**RE: McElliott Agricultural Short Plat (SP-16-00009)**

The Kittitas County Community Development Services Department has determined that the **McElliott Agricultural Short Plat (SP-16-00009)** is a complete application and hereby grants *conditional preliminary approval* subject to the following conditions:

# McELLIOTT AGRICULTURAL SHORT PLAT PART OF SECTION 20, T. 18 N., R. 19 E., W.M. KITITAS COUNTY, WASHINGTON

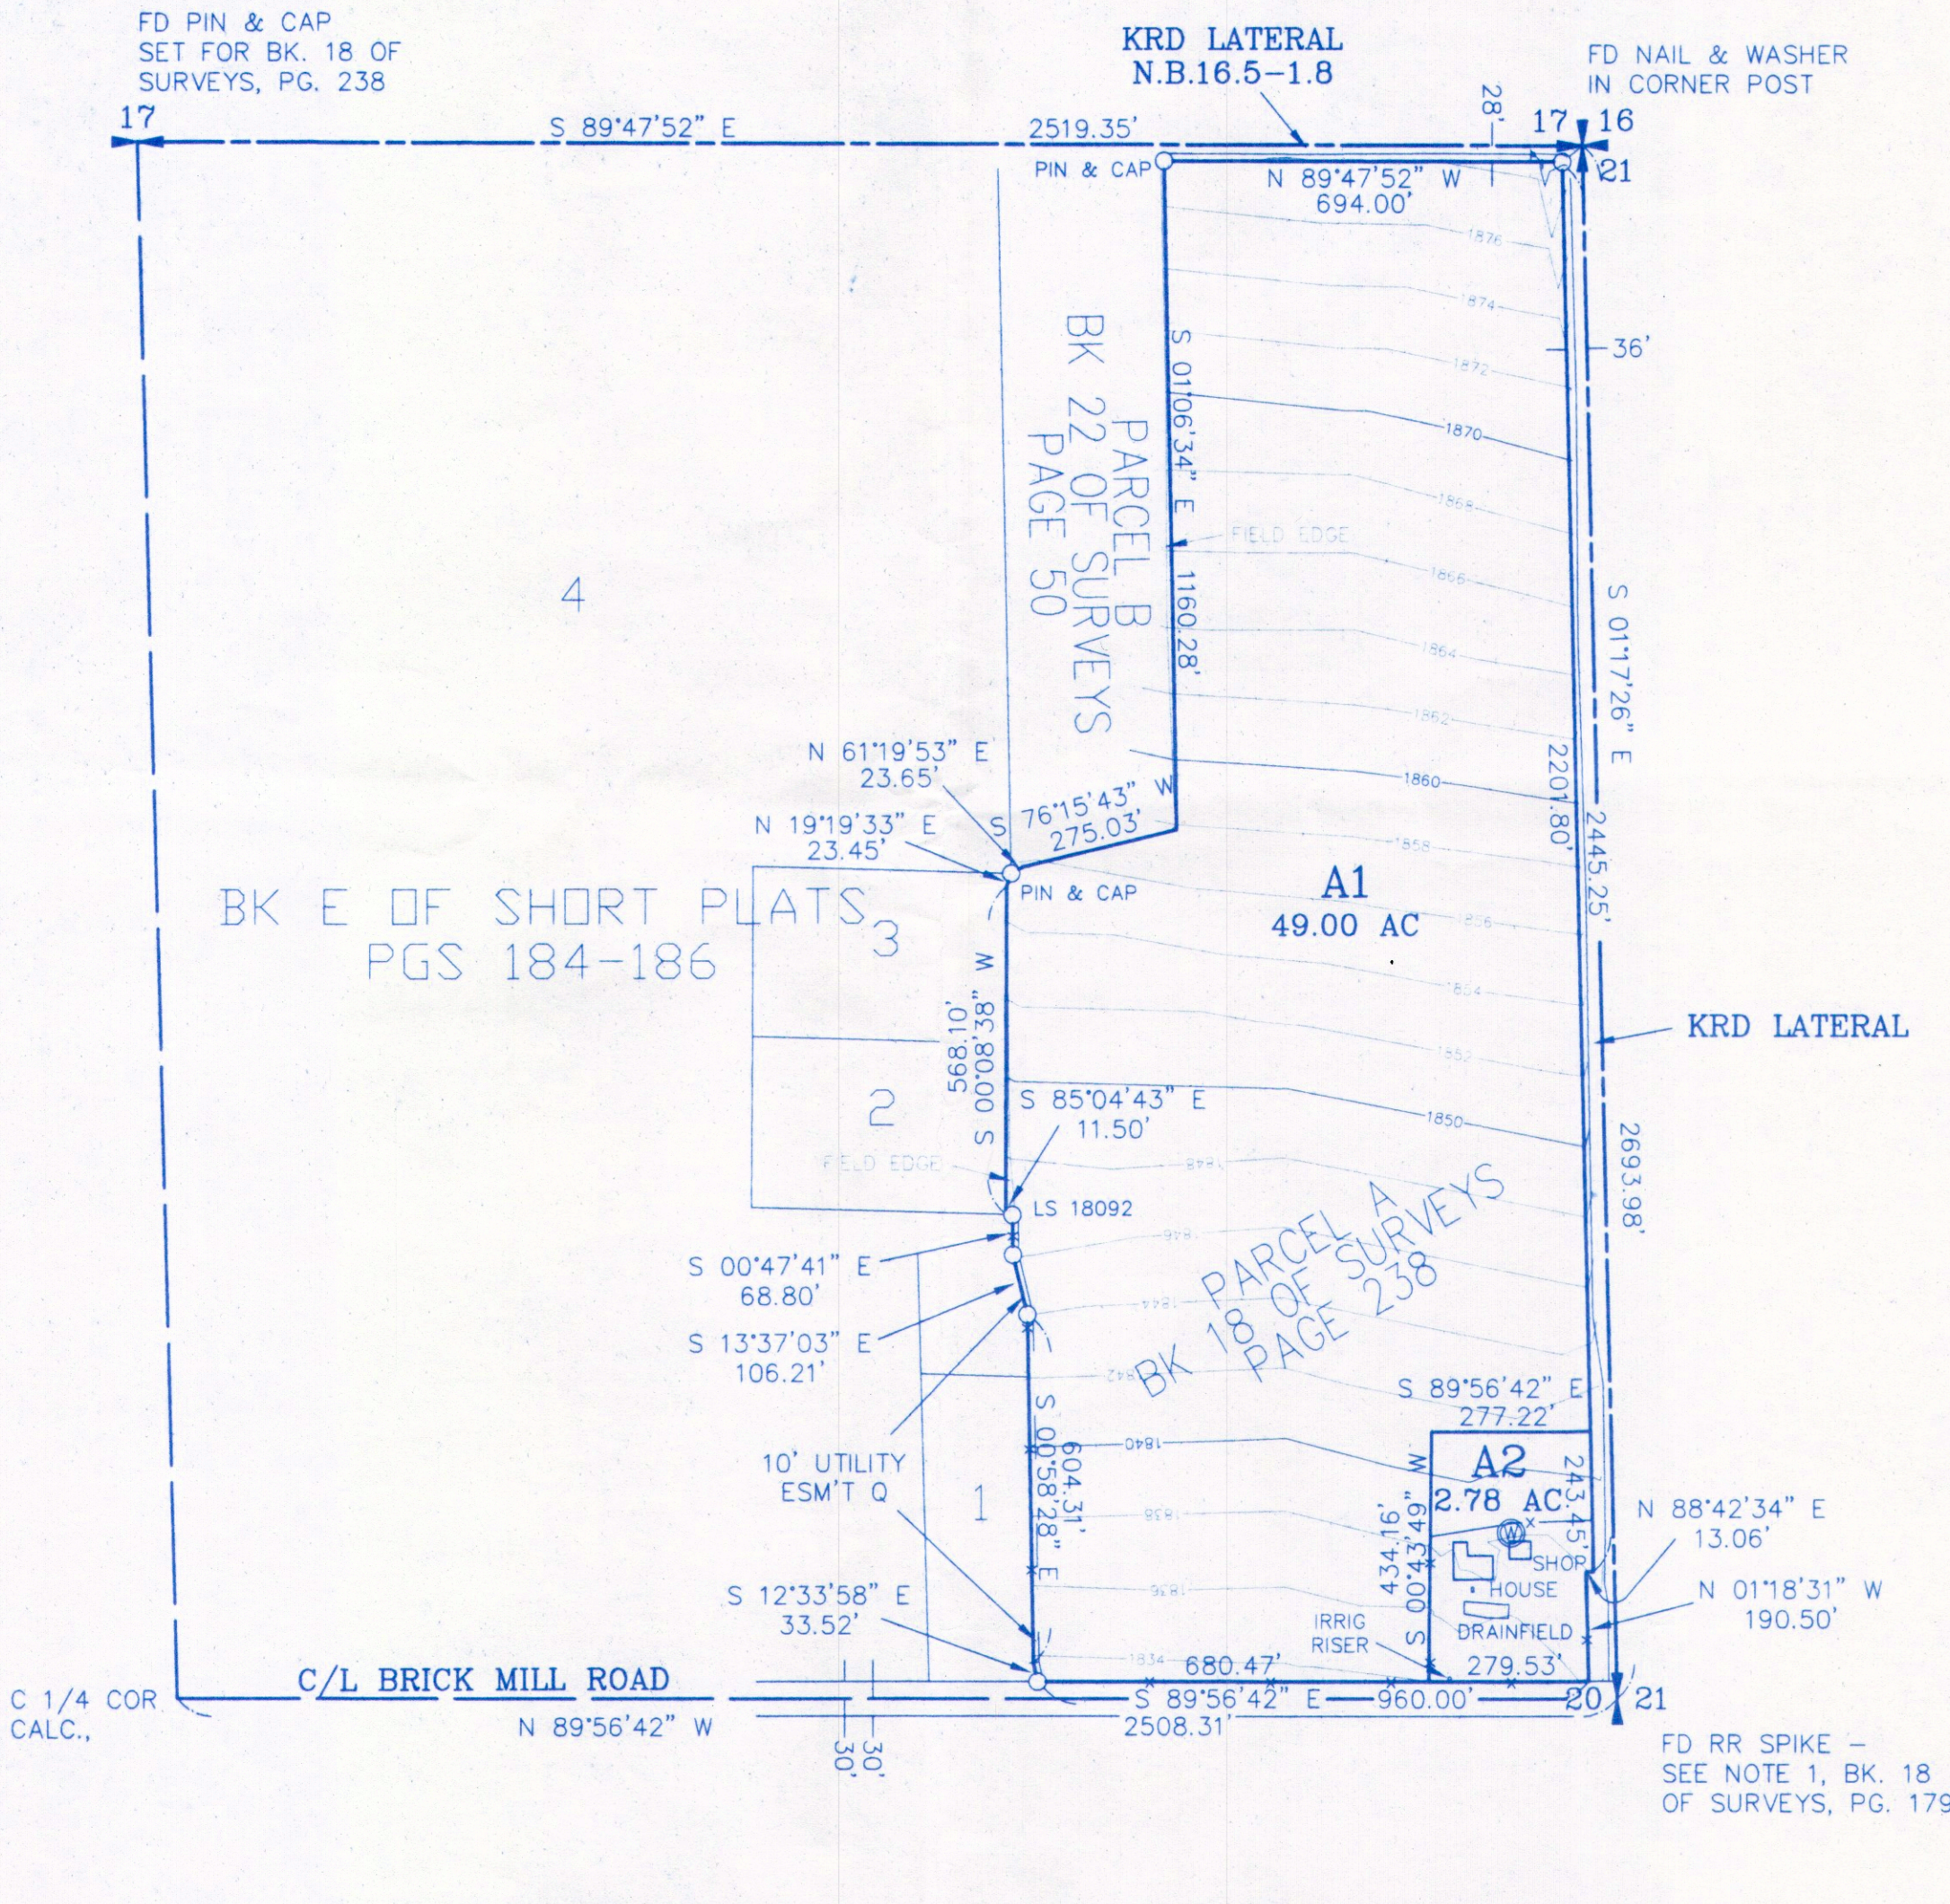
1. Both sheets of the final mylars shall reflect short plat number SP-16-00002 and an accurate legal description shall be shown on the face of the final plat. Engineers and Surveyors need to be cognizant of all of the requirements related to Final Plats (KCC 16.20) and Survey Data and Dedications (KCC 16.24). The final plat must be submitted in full conformance with these chapters of Kittitas County Code; **non-compliant mylars will be rejected and returned to the applicant.**

4. All Floodplain and wetlands shall be delineated on the face of the final mylar.
  5. Should ground disturbing or other activities related to the proposed short plat result in the inadvertent discovery of cultural or archaeological materials, work shall be stopped in the immediate area and contact be made with the Washington State DAHP. Work shall remain suspended until the find is assessed and appropriate consultation is conducted. Should human remains be inadvertently discovered, as dictated by Washington State RCW 27.44.055, work shall be immediately halted in the area and contact made with the coroner and local law enforcement in the most expeditious manner possible.
